Application for a non-material amendment following a grant of planning permission.
 Town and Country Planning Act 1990

TWO STOREY AND SINGLE STOREY REAR EXTENSIONS, HIPPED ROOF OVER FLAT ROOF AND FENESTRATION ALTERATIONS

DM/21/03347/FPA

REAR ELEVATION FENESTRATION CHANGED TO FACE BRICKWORK IN LIEU OF APPROVED RENDER, AND ADDITIONAL WINDOWS ADDED EITHER SIDE OF FRENCH DOORS.

PROPOSED FIRST FLOOR LAYOUT..

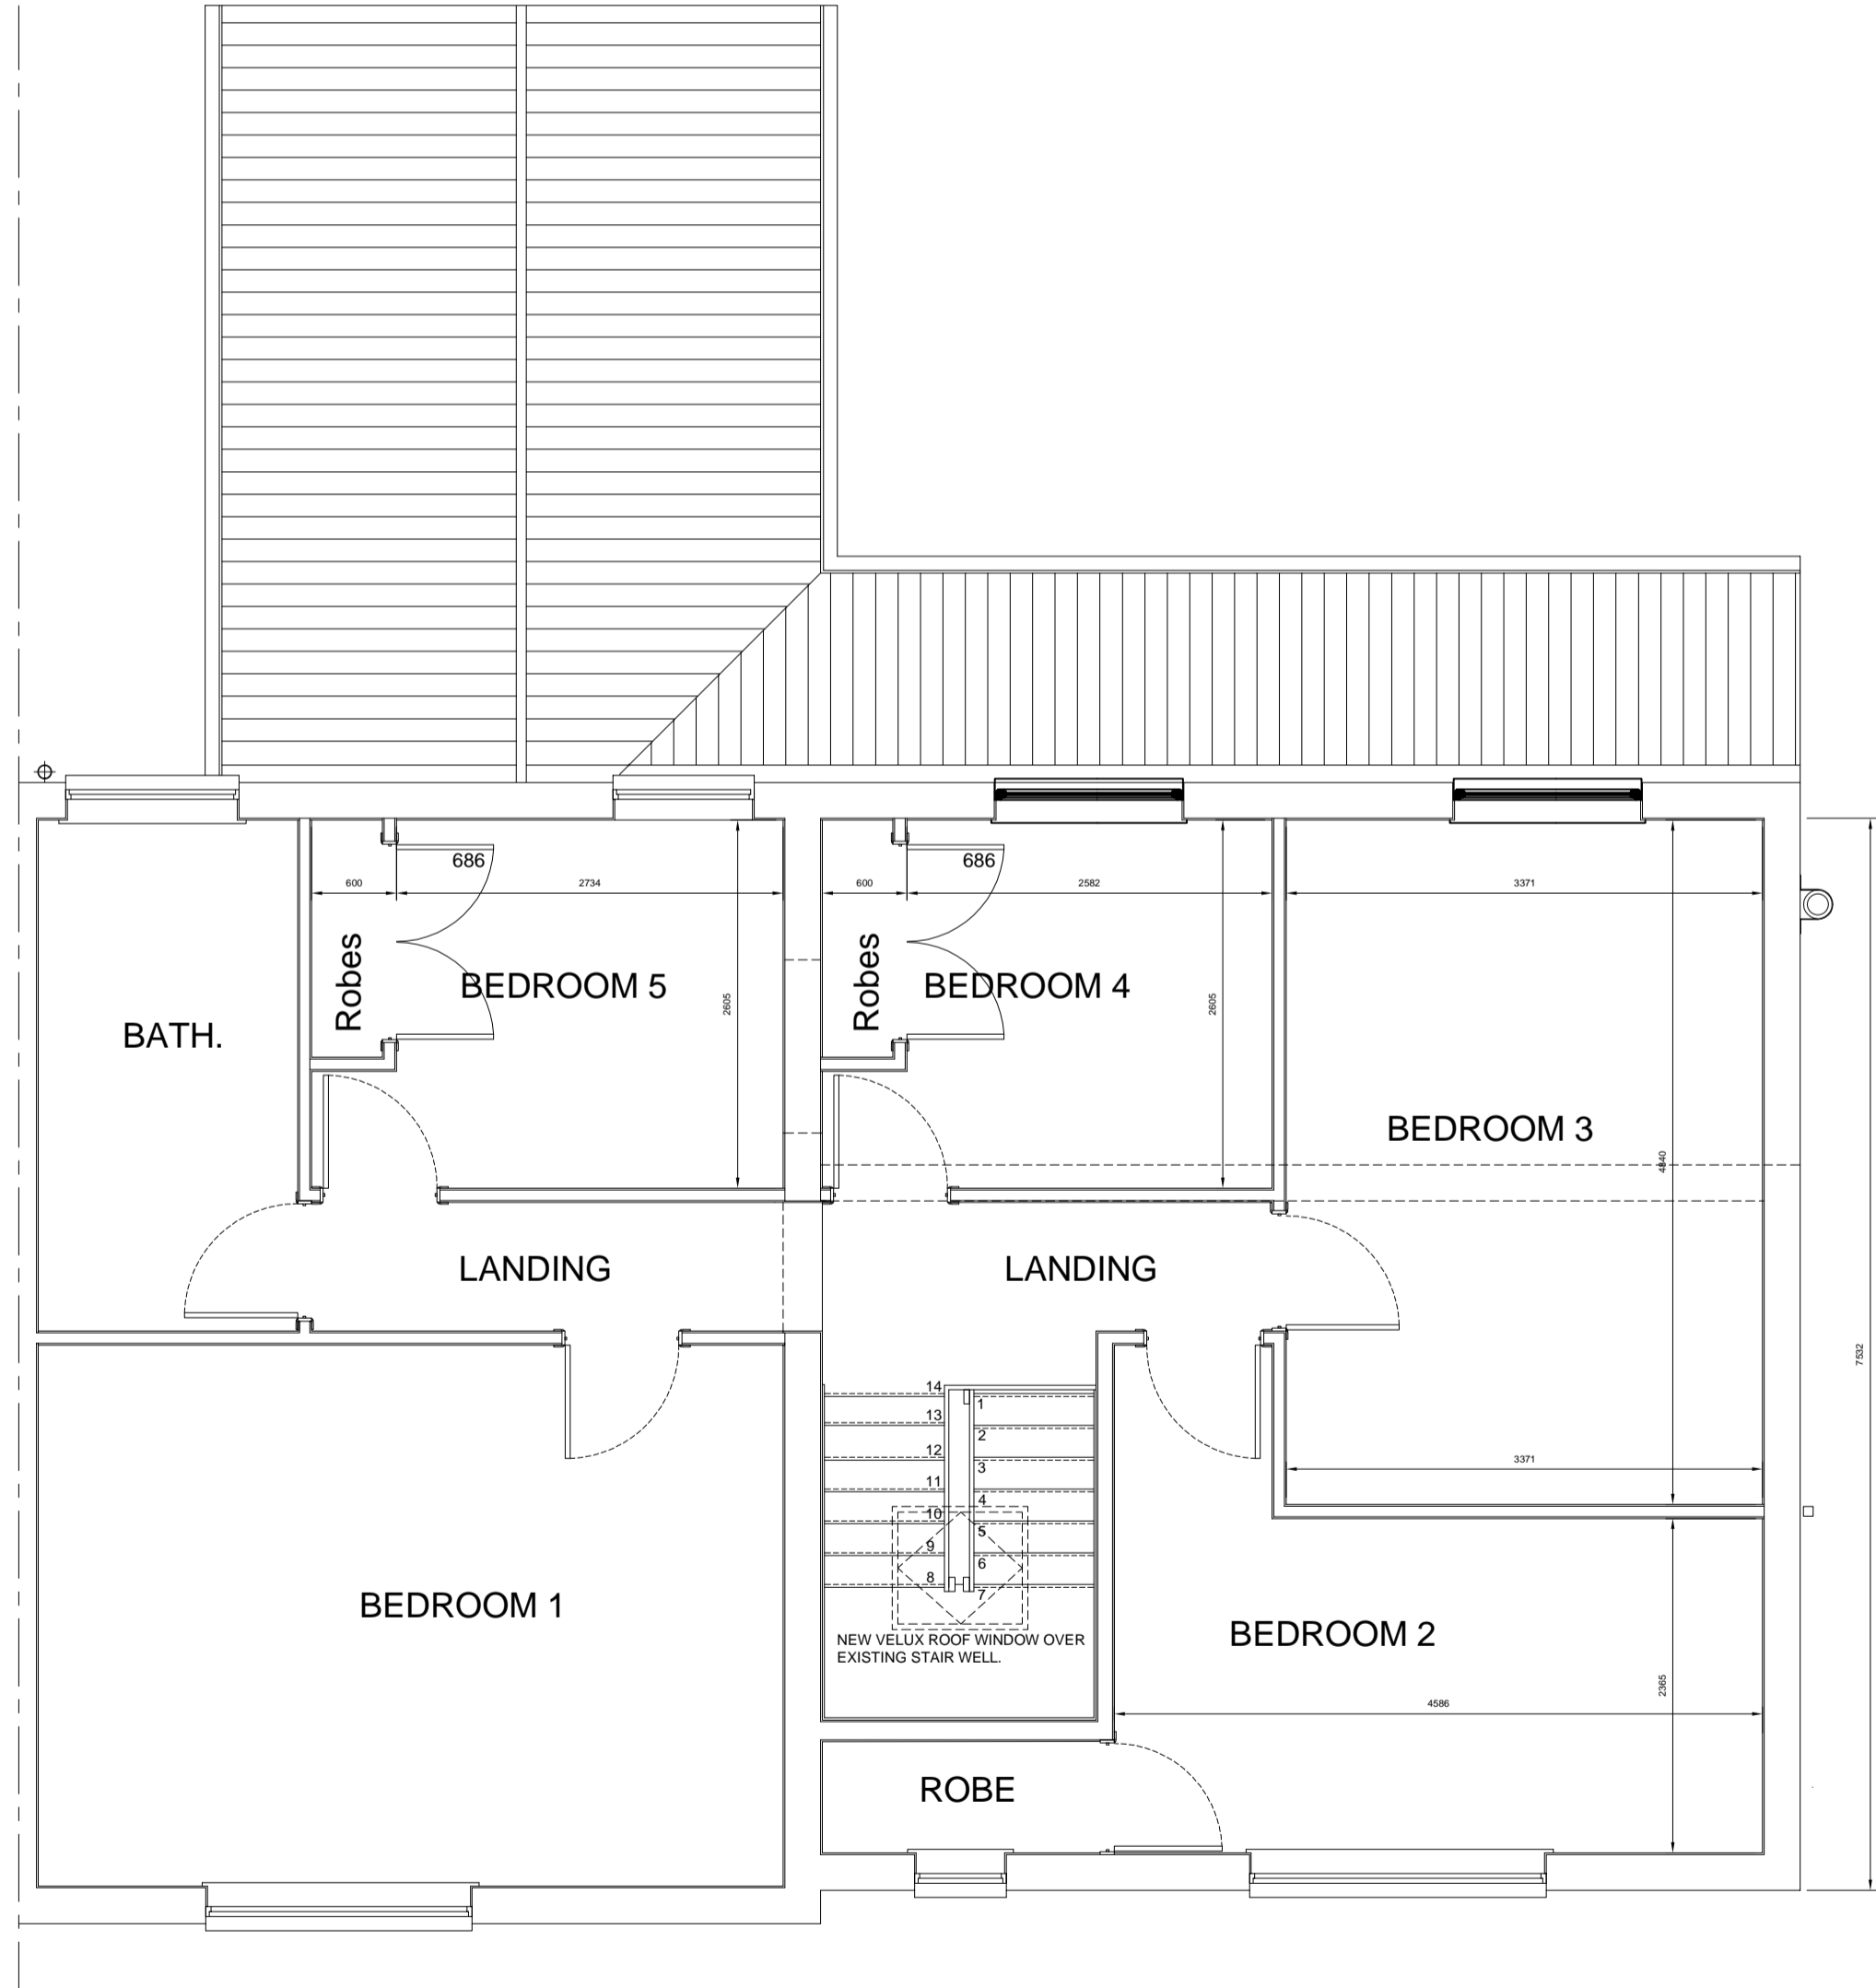
TO MATCH NEW REAR ELEVATION WITH EXISTING.
ADDITIONAL WINDOWS TO PROVIDE MORE NATURAL LIGHT TO DINING ROOM EXTENSION.
